# CITY OF ALBUQUERQUE

**Re: Nusenda Admin Bldg A**  
**4100 Pan American Fwry. NE 87198**  
**30-Day Temporary Certificate of Occupancy**  
**Transportation Development Final Inspection**  
Engineer's/Architect's Stamp dated 3-7-18(AA) (G16D154)  
Certification dated 8-27-19

LOWER LEVEL
SITE PLAN
SITE DETAILS

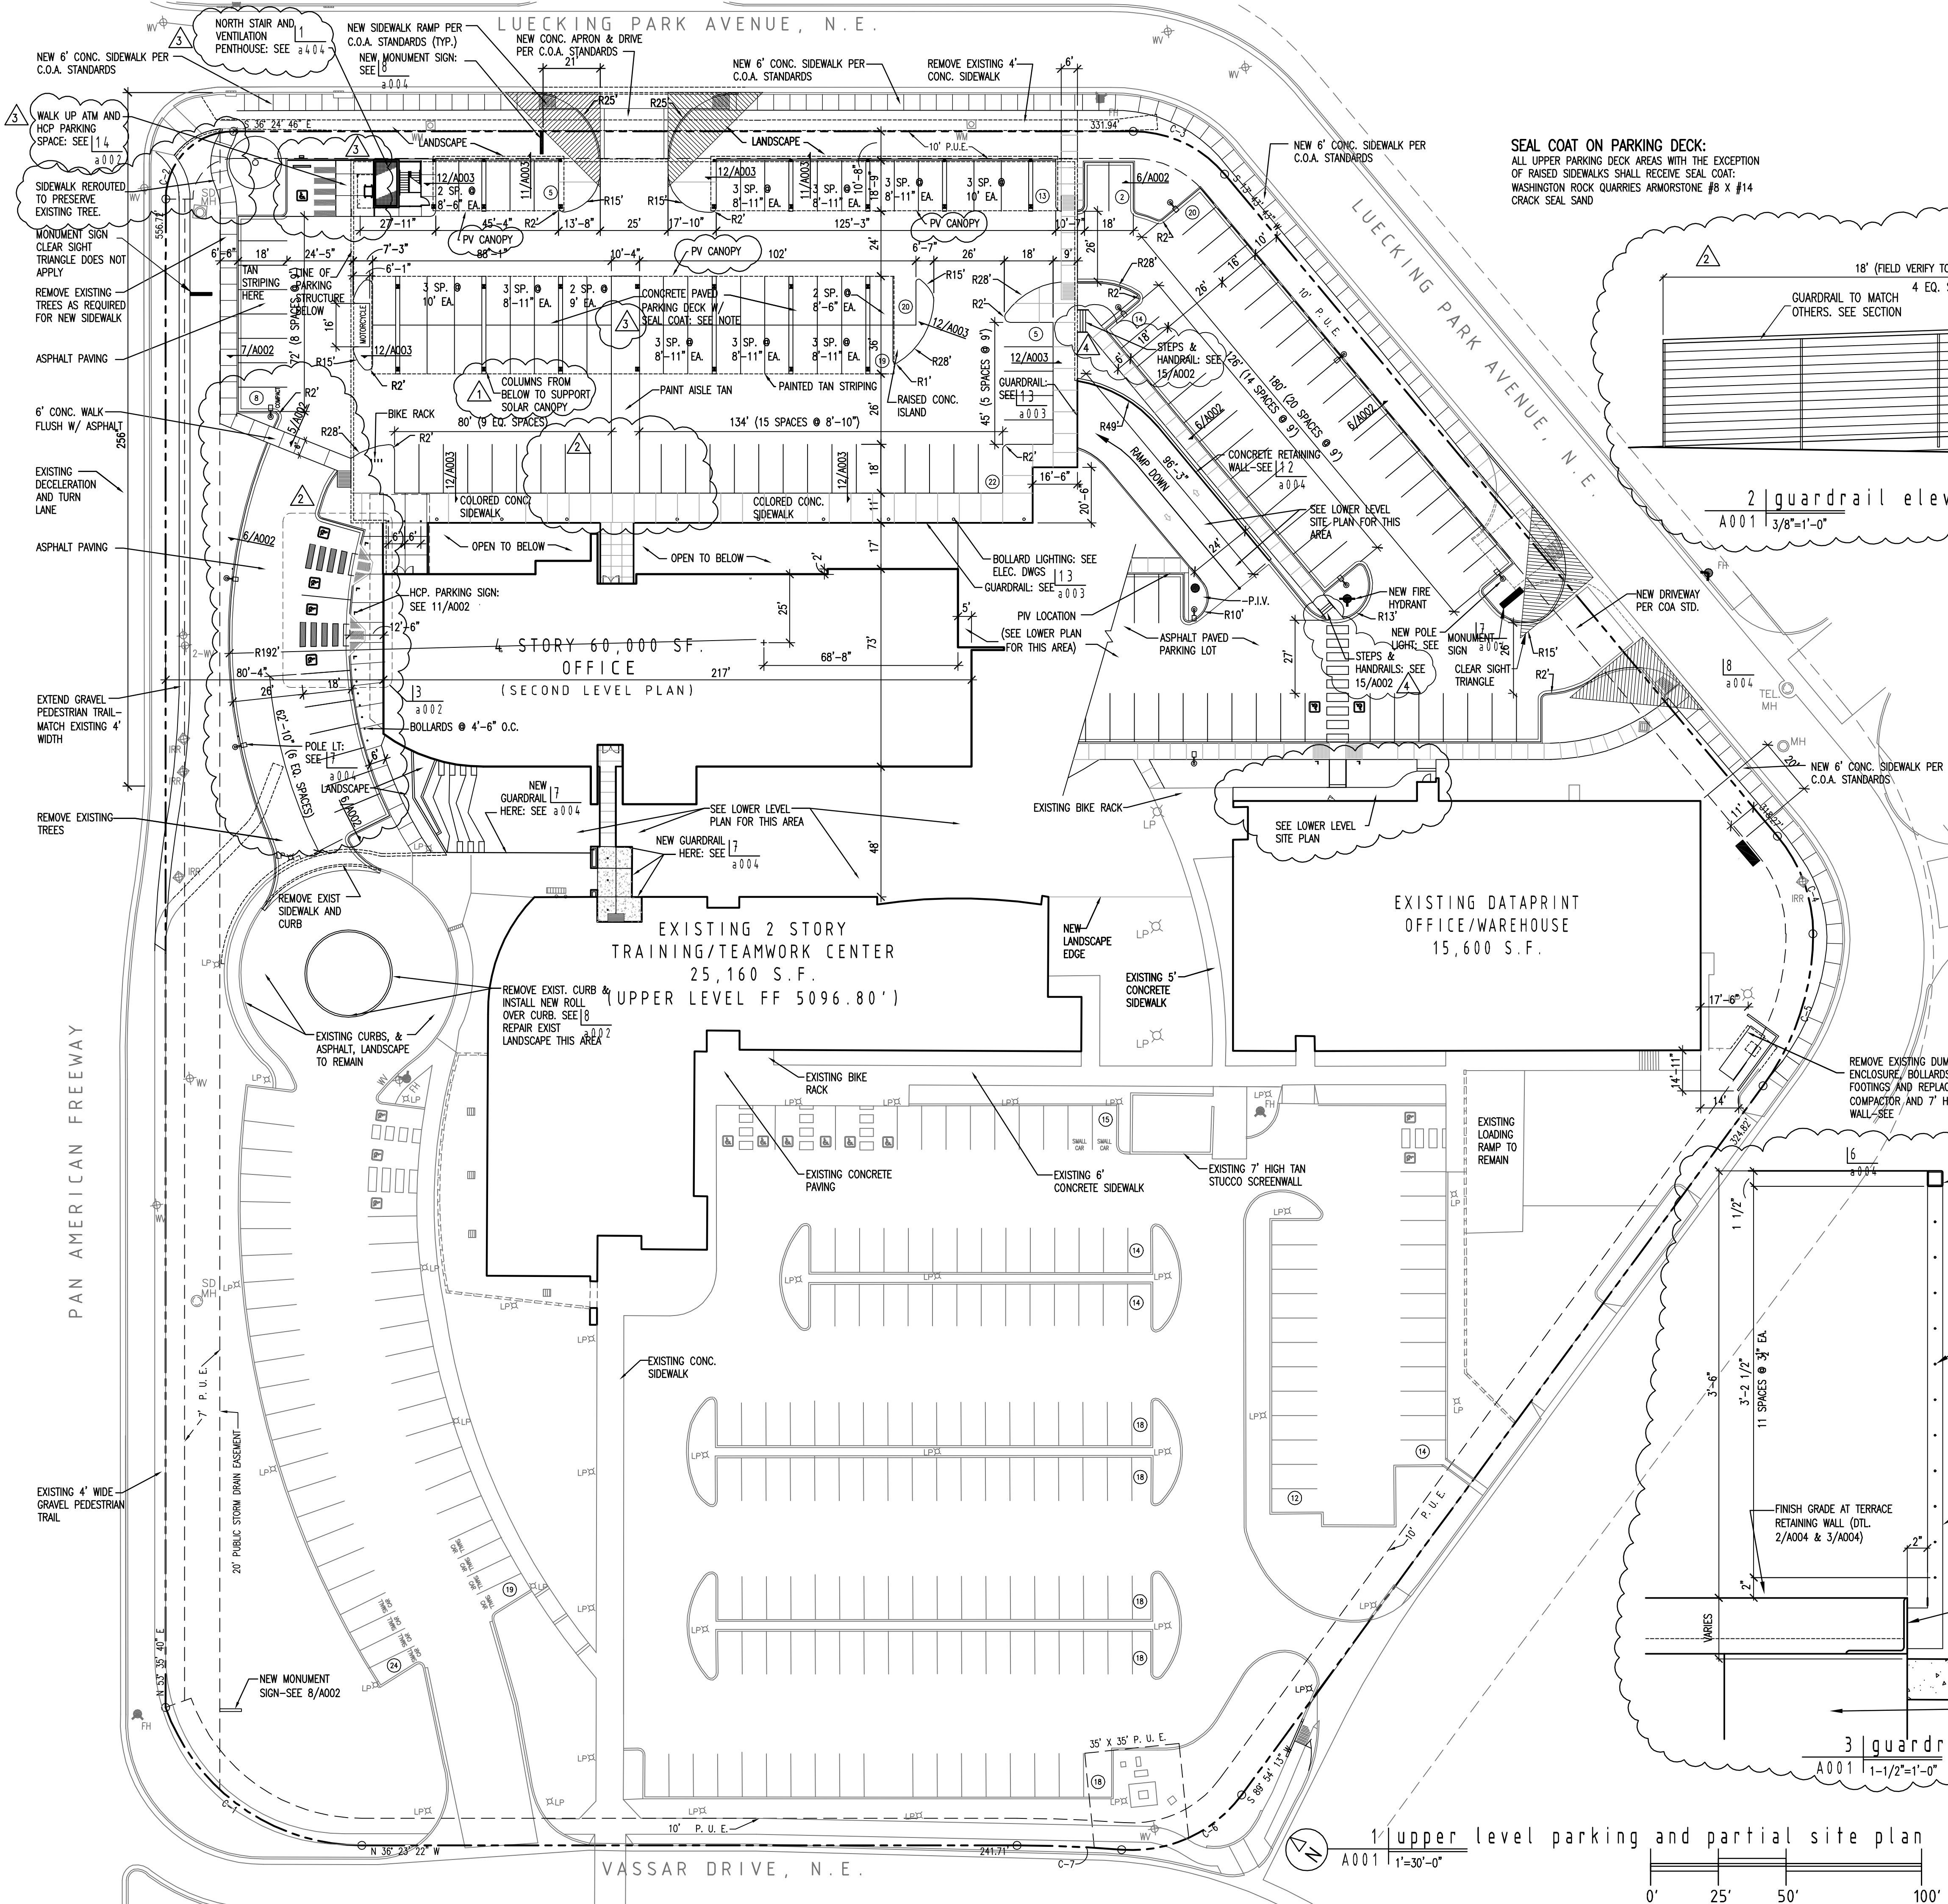
- **Motorcycle parking spaces shall be designated by its own conspicuously posted upright sign, either free-standing or wall mounted per the zoning code.**
- **Please remove trash container, construction equipment & debris.**
